City of Portland, Maine - Building or Use Permit Application

Permit No: 02-0190	Issue Date: MAR 13 2002	CBL: 087 W001001
-----------------------	----------------------------	---------------------

Proposed Project Description: Build 16' x 10' deck and add patio door.	FIRE DEPT: <input type="checkbox"/> Approved <input type="checkbox"/> Denied	INSPECTION: Use Group <i>R3</i> Type <i>SB</i> <i>BOCA 1999</i>
	Signature:	Signature: <i>MUNSO</i>

WEST ELEV.
SCALE: 1/4" = 1'-0"

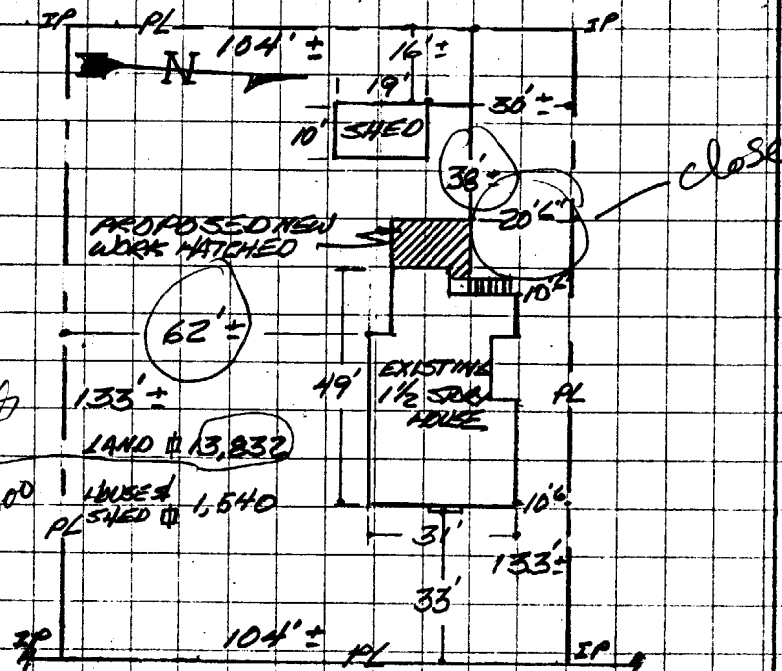
Girder needs to be 4"x10" or add one more sawntube.

PROPOSED COSTELLO DECK

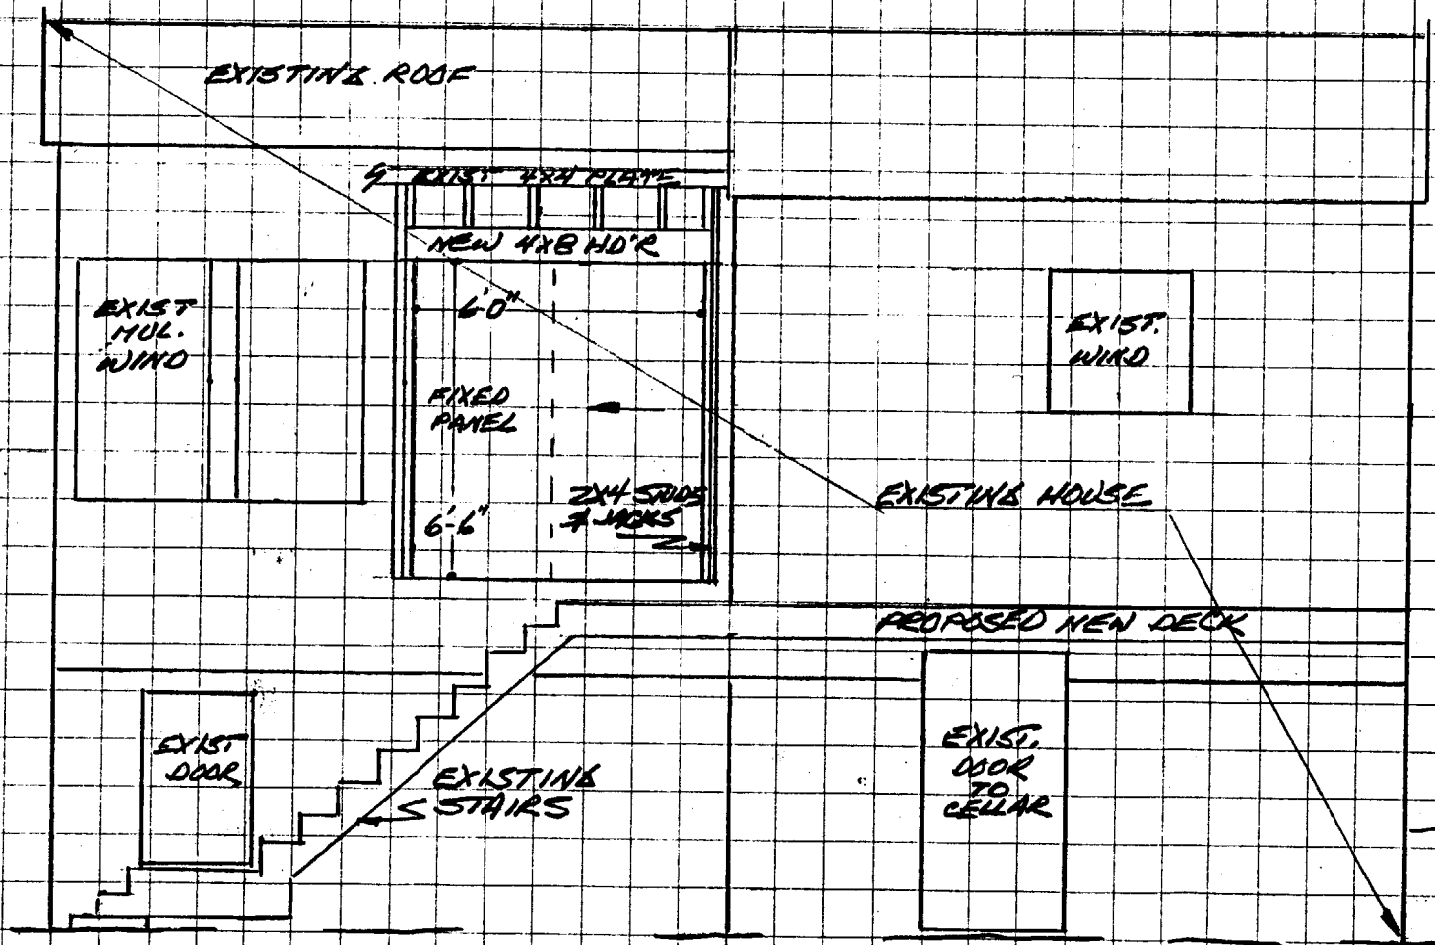
3-12-06 Sawntube depth needs to be 4'-0" + 8" Min dia.

Guardrails need to be 36" around new deck.

3- 2x12 stringers - 10" Tread + Max $7\frac{3}{4}$ " rise -
guards 36" high - stairs will be rebuilt
in same footprint - OK per 14-385.
